Attachment B - Response to the Government Architect's Office Response

7 Section Retail Facade Option A_Fixed glazing
1 : 50

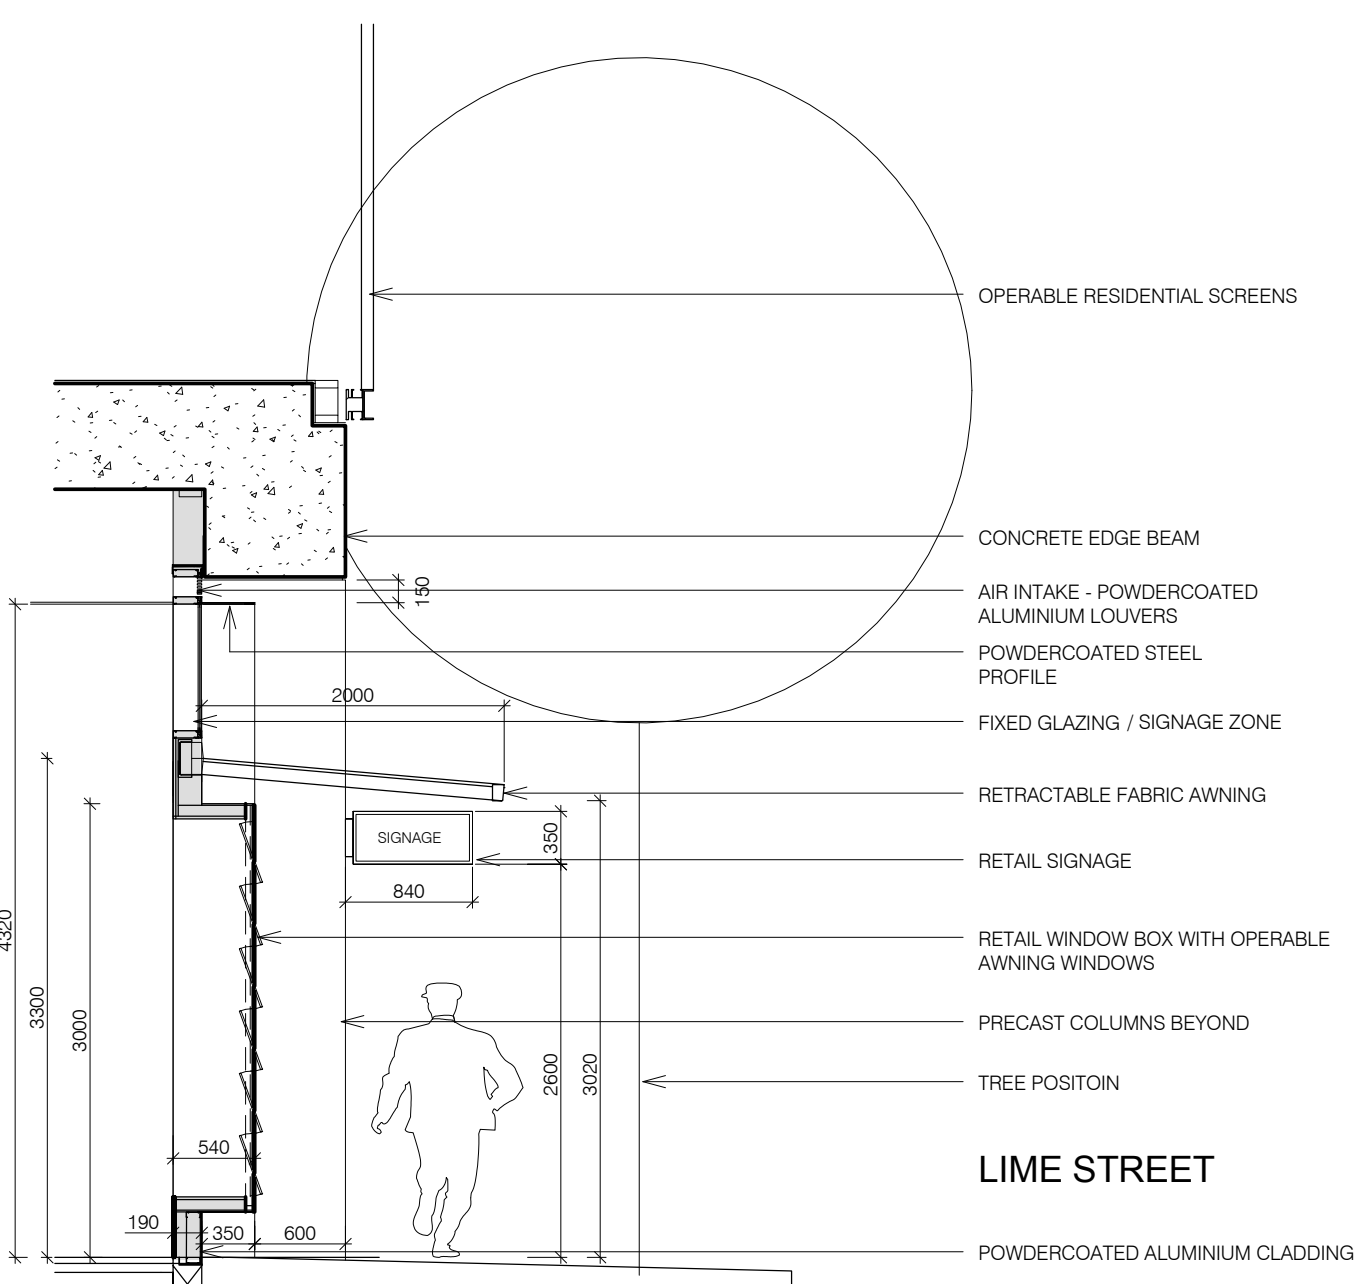
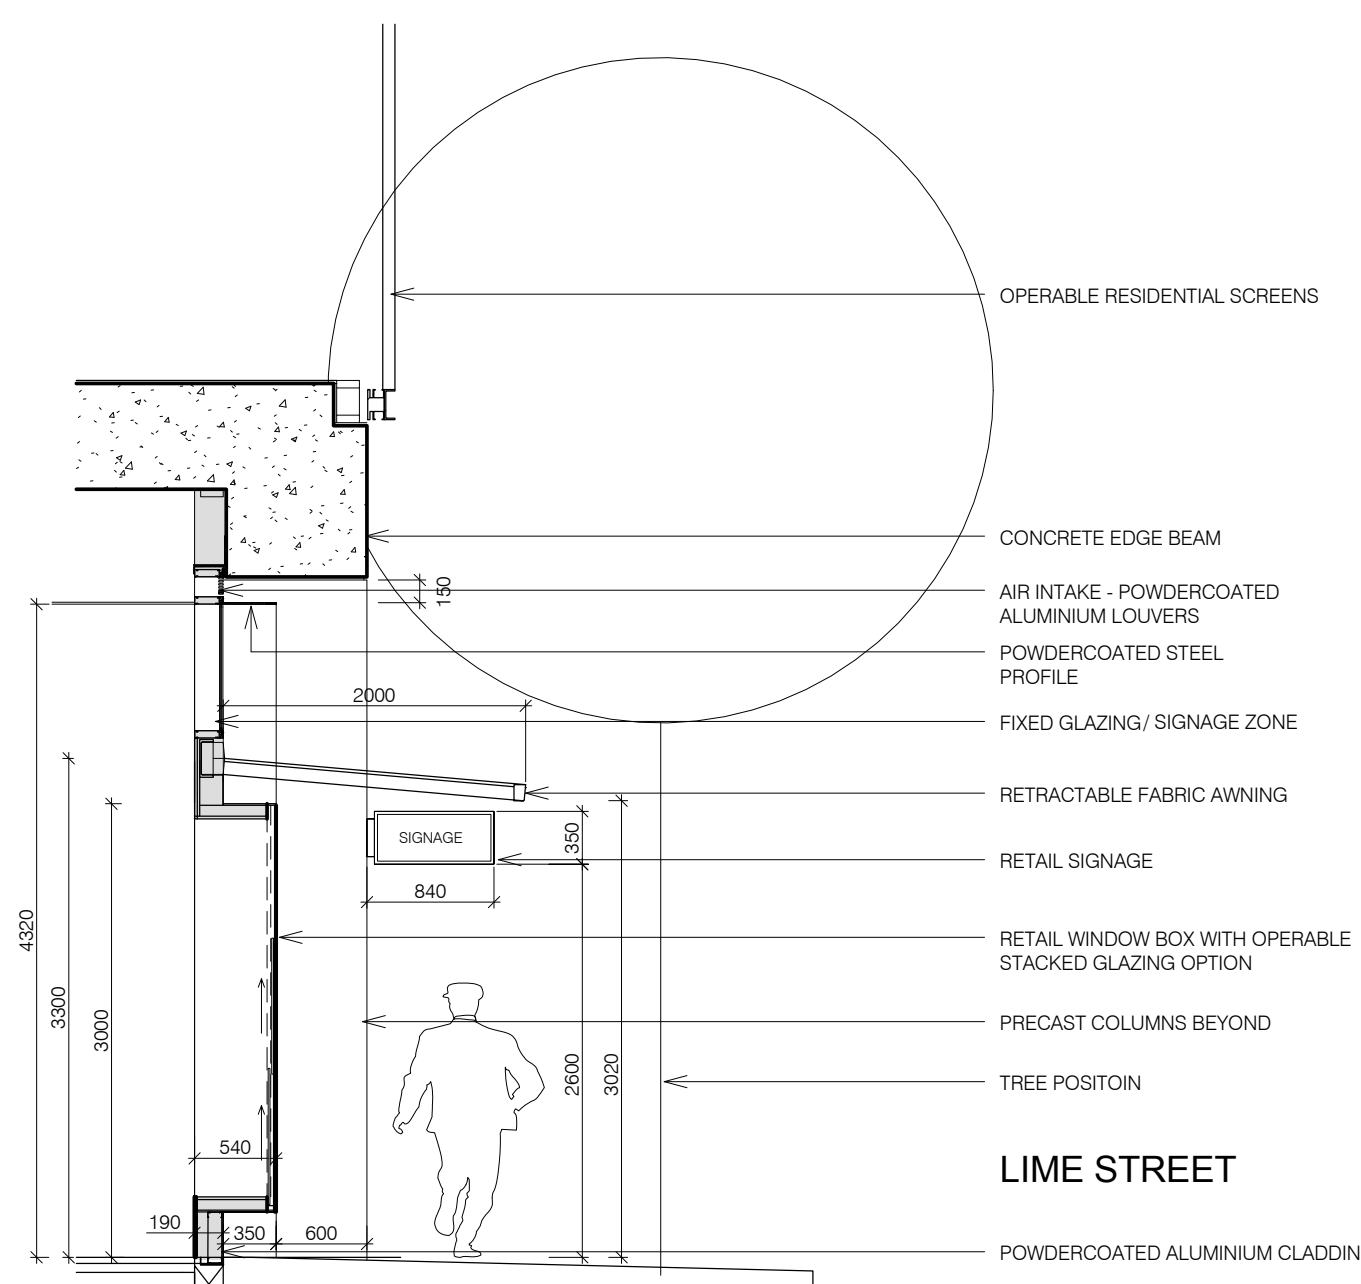
| Government Architect's Office Comment | Applicant Response |
|---|---|
| <p>The overall design intent for the shop fronts to Lime Street, including the method for the selection of shopfront types (R9) is not clear. Four options are provided for R9. As above, a minimum or maximum number of shop front types to be used would clarify the design intent on this elevation.</p> | <p>See response above.</p> |
